ADDENDUM NO 01

date: May 17, 2013
project: Alford Residence (2013-00040)
from: Harry Hepburn, Scott Simons Architects
to: Steve Brann Building & Remodeling
cc: File

This Addendum forms a part of and modifies the Contract Documents for the Alford Residence, Renovations and Addition, Issued For Construction May 6, 2013. Receipt of this addendum shall be acknowledged on the Bid Form.

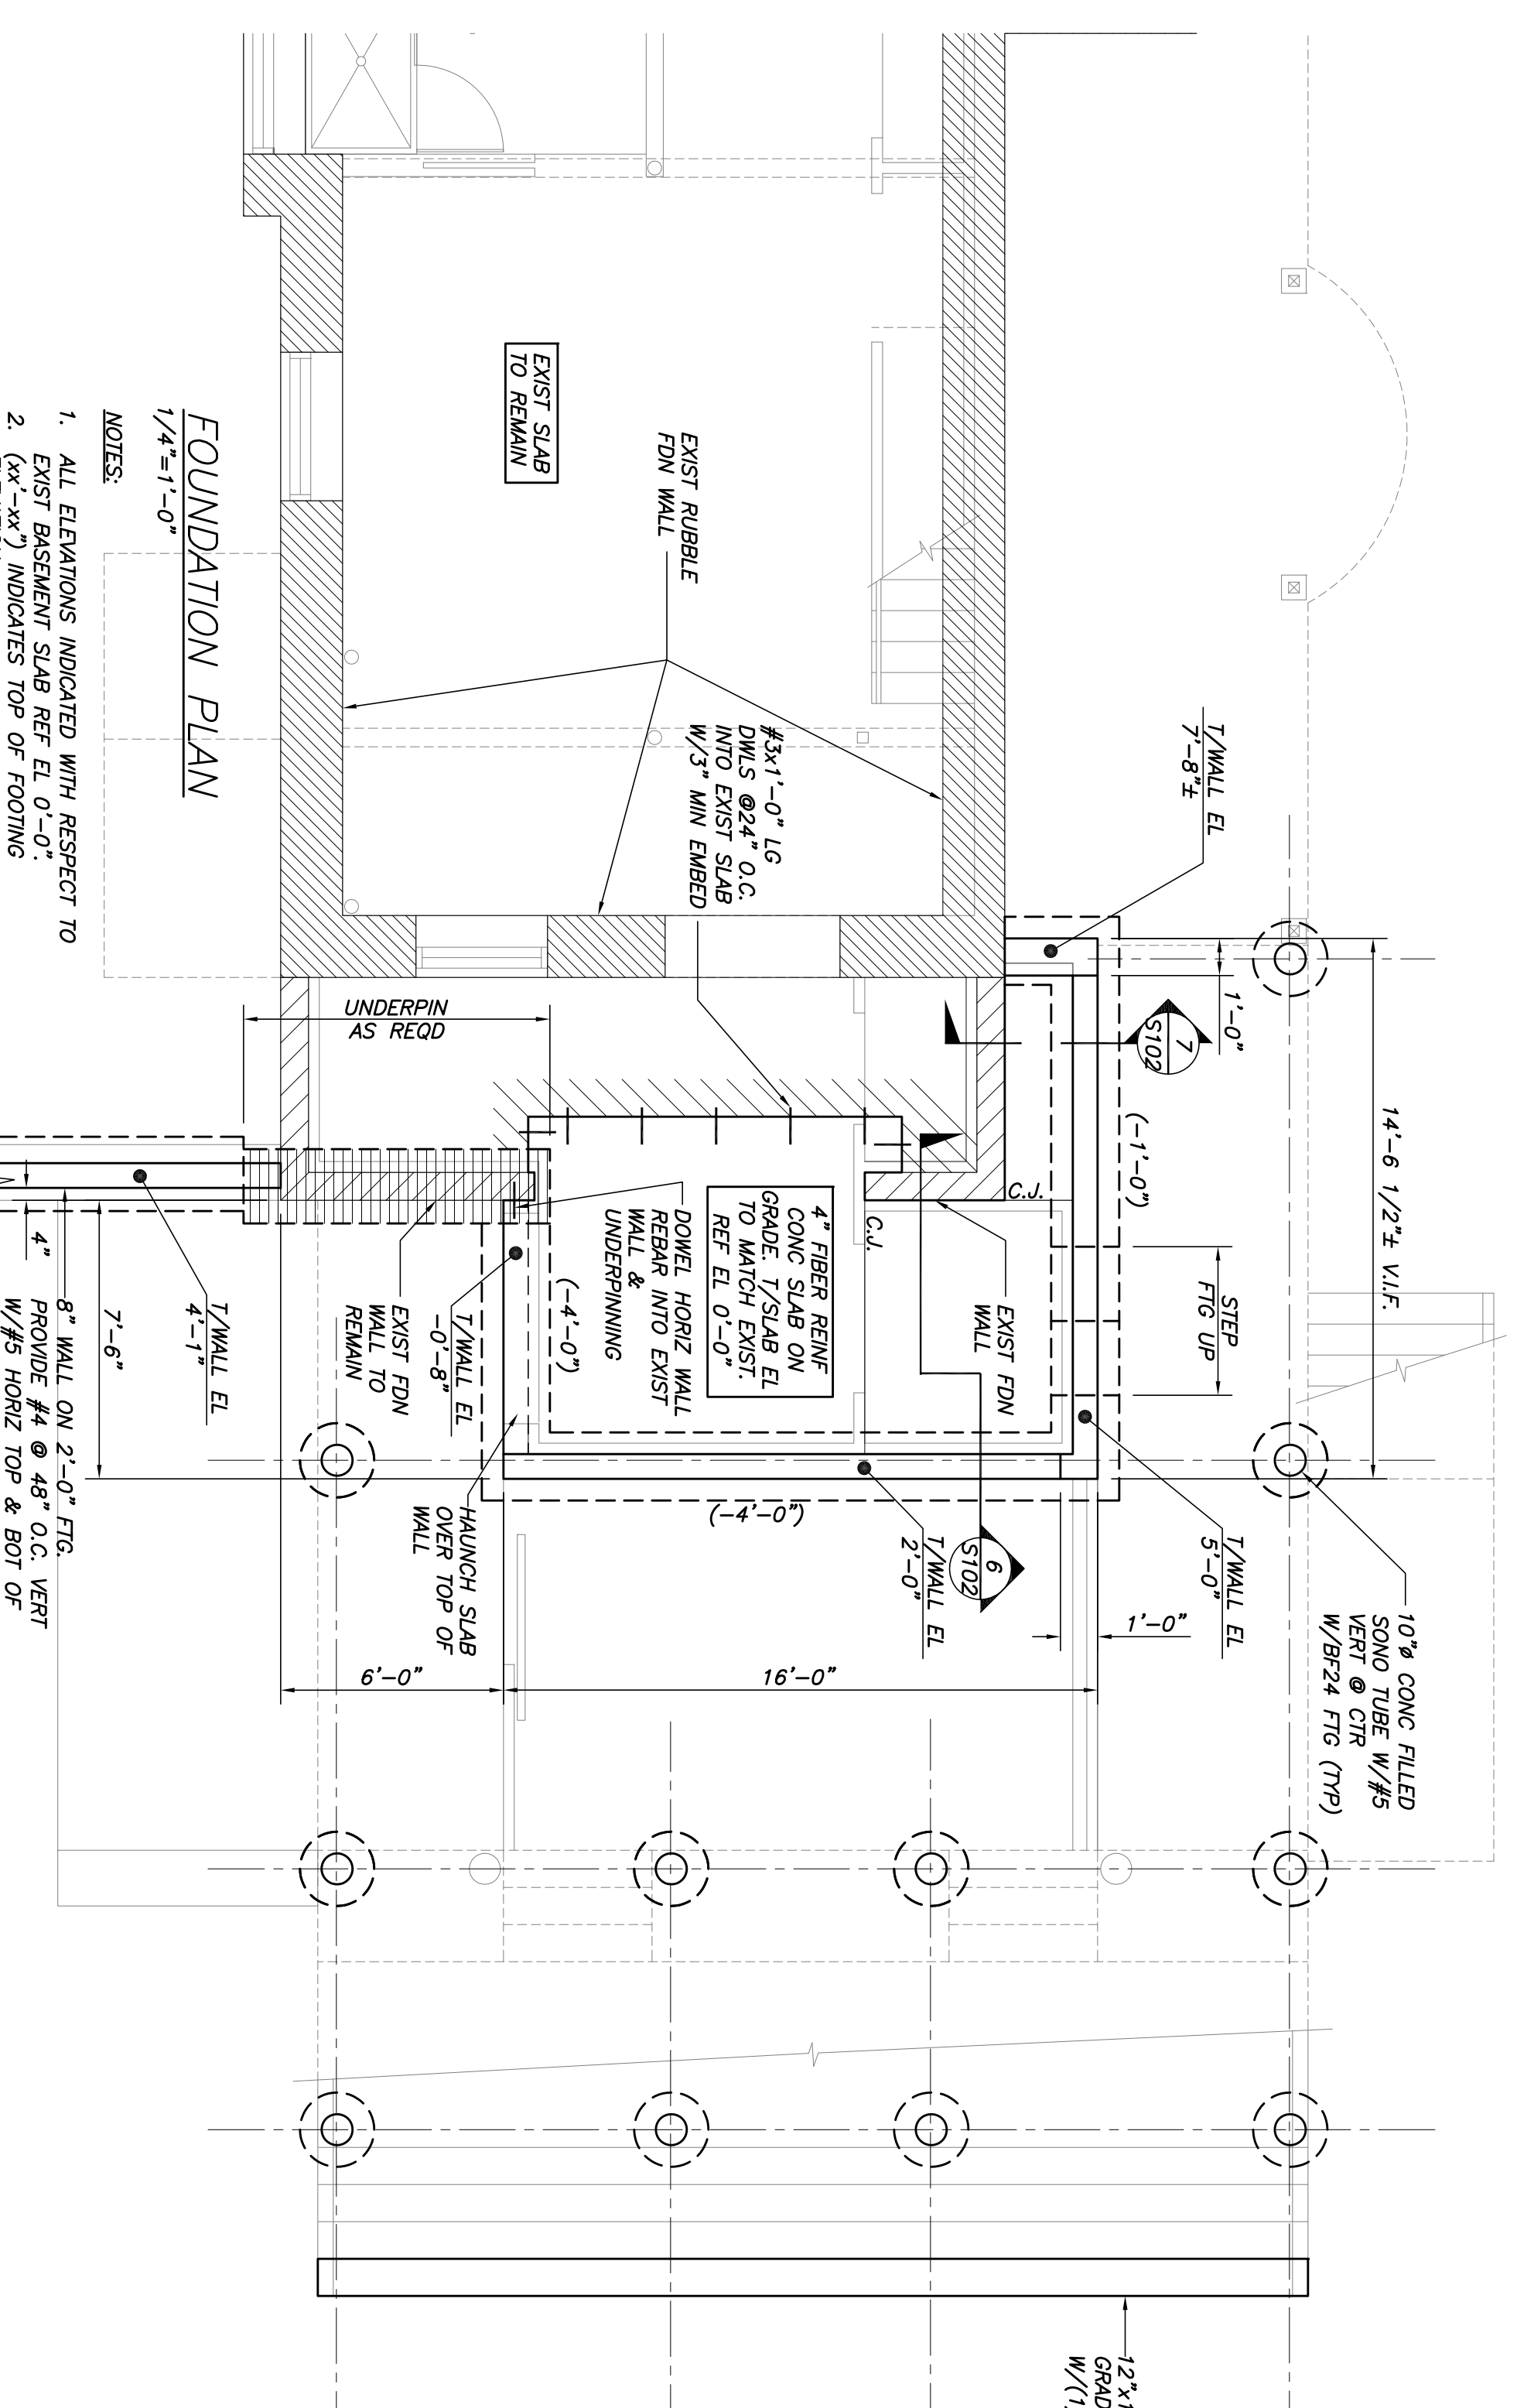
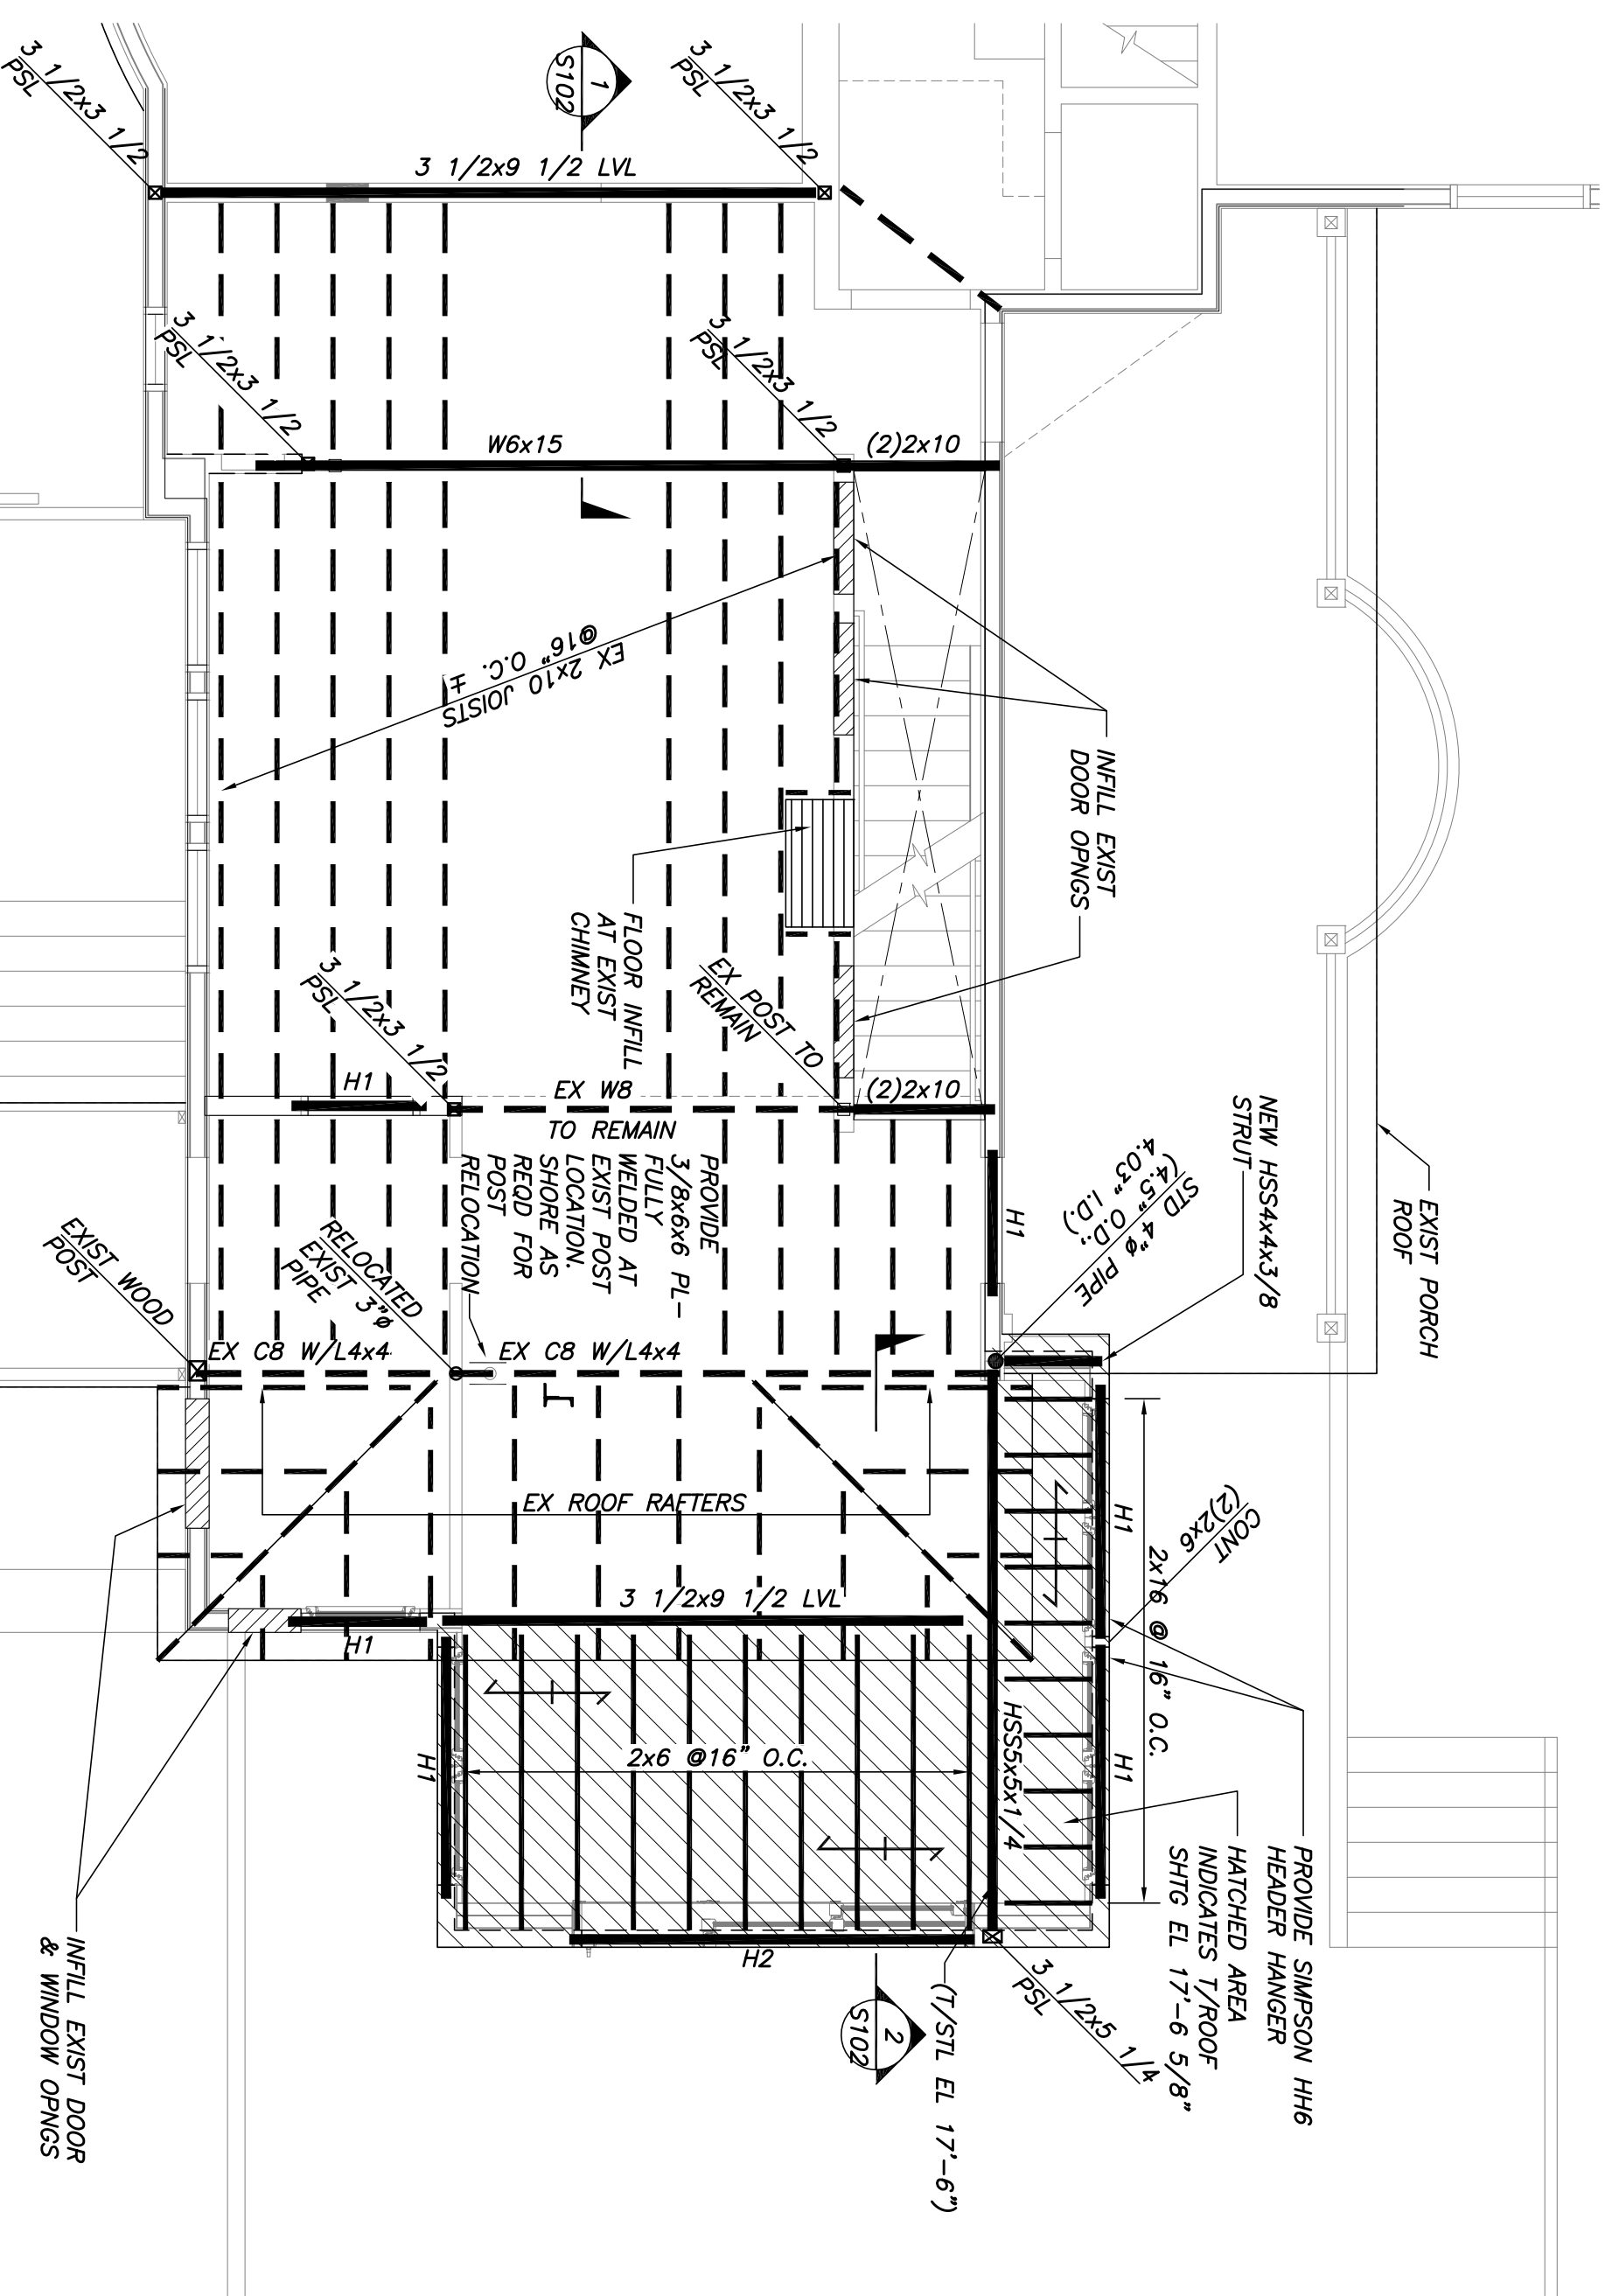
D1 S101: Revise deck framing and foundation plan per the attached sketches (SKS-01, SKS-02 and SKS-03).
D2 Detail 5/S101 on sheet S102: Revise per the attached sketch (SKS-03).
D3 S101, Foundation Plan: Add the following note; “Widen footing on uphill side of retaining wall, south of existing home, by 1 foot as required to help resist pressure of earth beyond. Backfill evenly on both side of footing and wall.
